From: dc.support@cherwell-dc.gov.uk
Sent: 30 August 2022 10:04
To: DC Support
Subject: New comments for application 22/01488/OUT

New comments have been received for application 22/01488/OUT at site address: OS Parcel 5616 South West Of Huscote Farm And East Of Daventry Road Banbury

Comment type:
Objection

Frontier Park Infrastructure

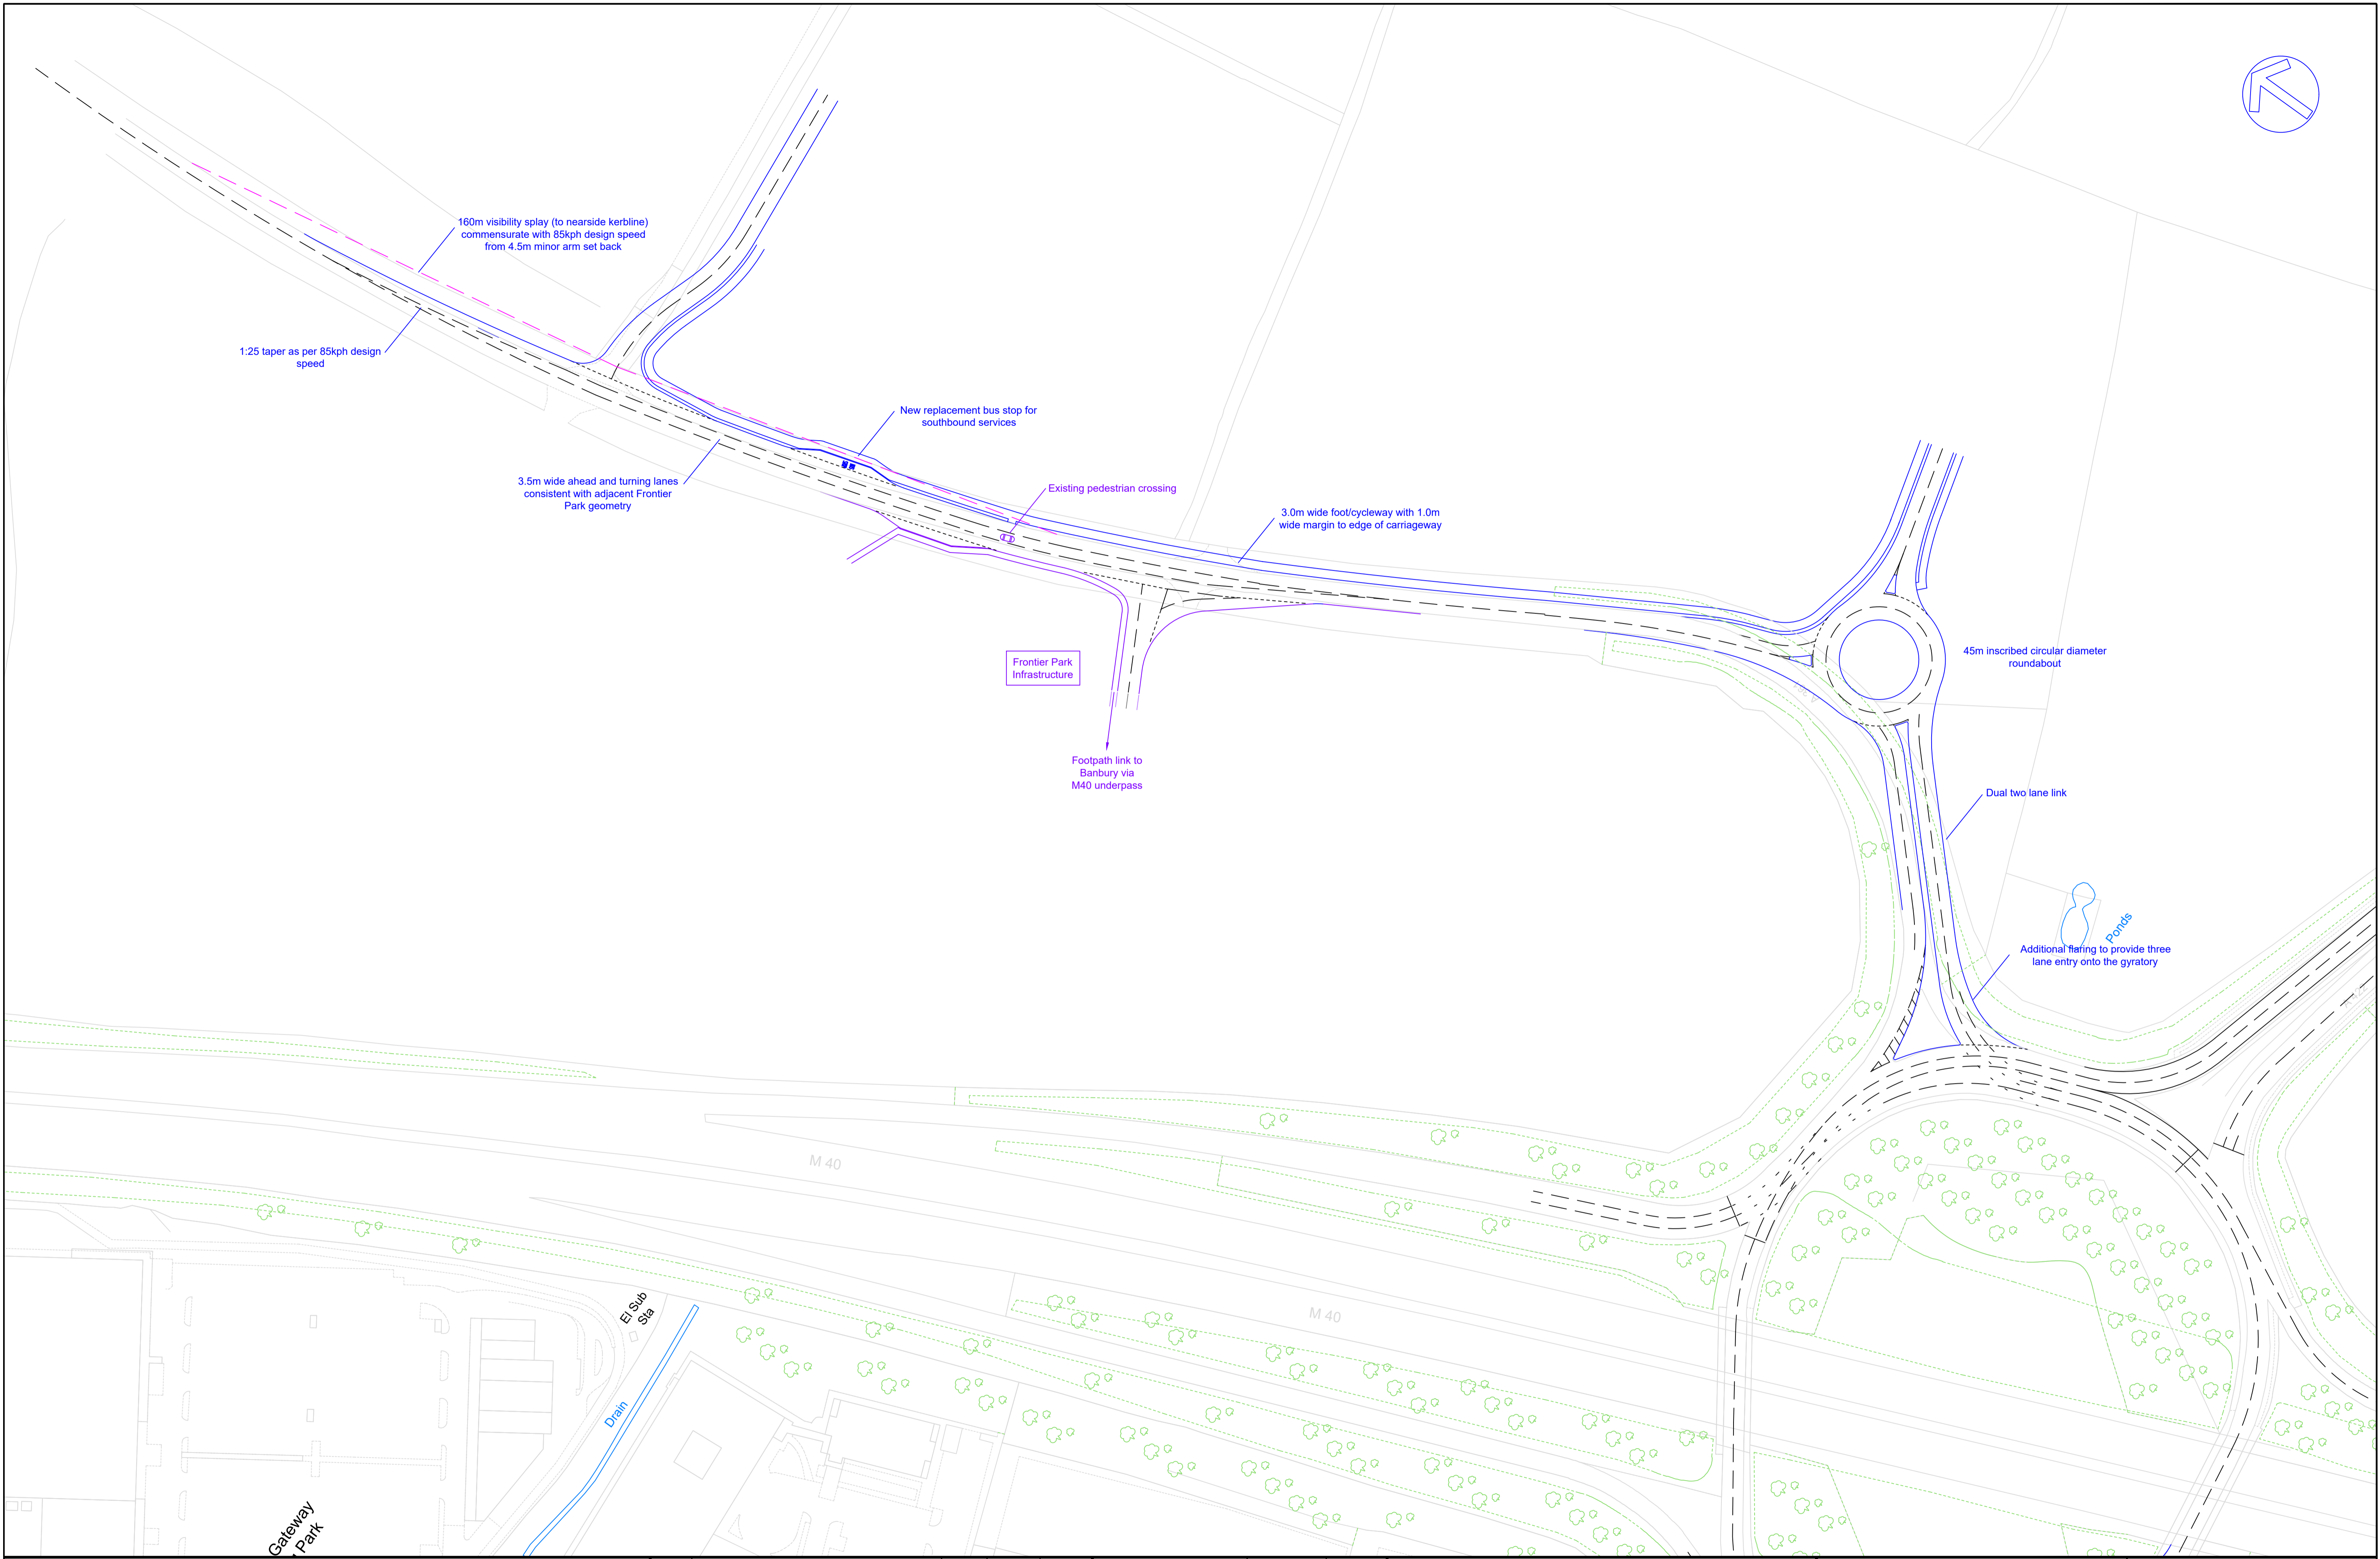
Objection: Traffic arrangements seem badly thought out.

Having a mini-roundabout just off the J11 roundabout is ridiculous as traffic will back up across the motorway junction.
